Hugh & Susan Webb  
1129 Edith Road  
OBERON NSW 2787

20 January 2011

RE: Submission Oberon White Granite Quarry Environmental Assessment.

Figure 2.7 shows the existing intersection and proposed additional works.

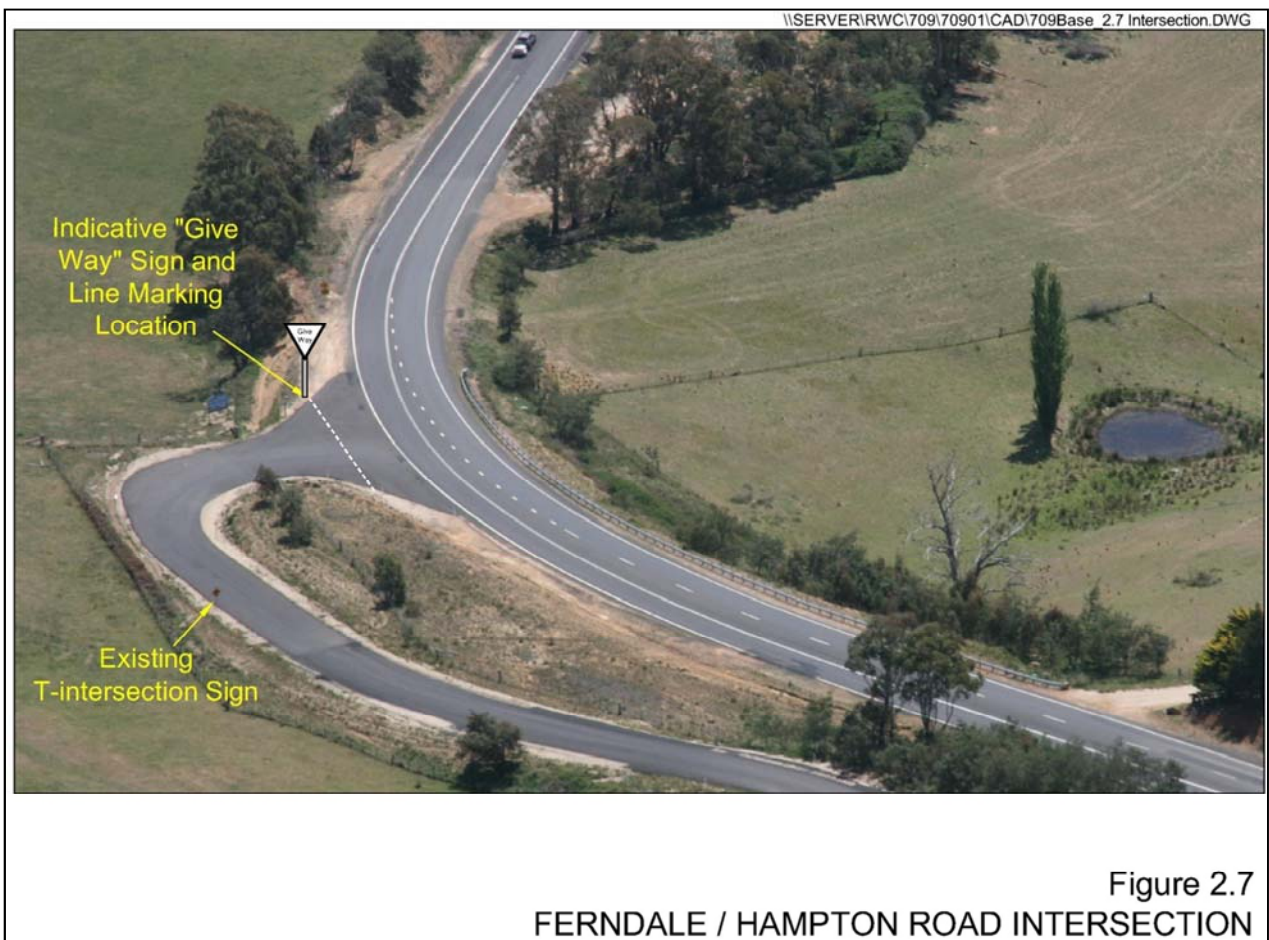
- 1) The intersection Duckmaloi Road & Ferndale Road. Already has been one fatal car accident Refer Oberon Review Thursday July 9 2009. This intersection is not suitable for loaded trucks to be turning East from Ferndale Road, across west bound lane.
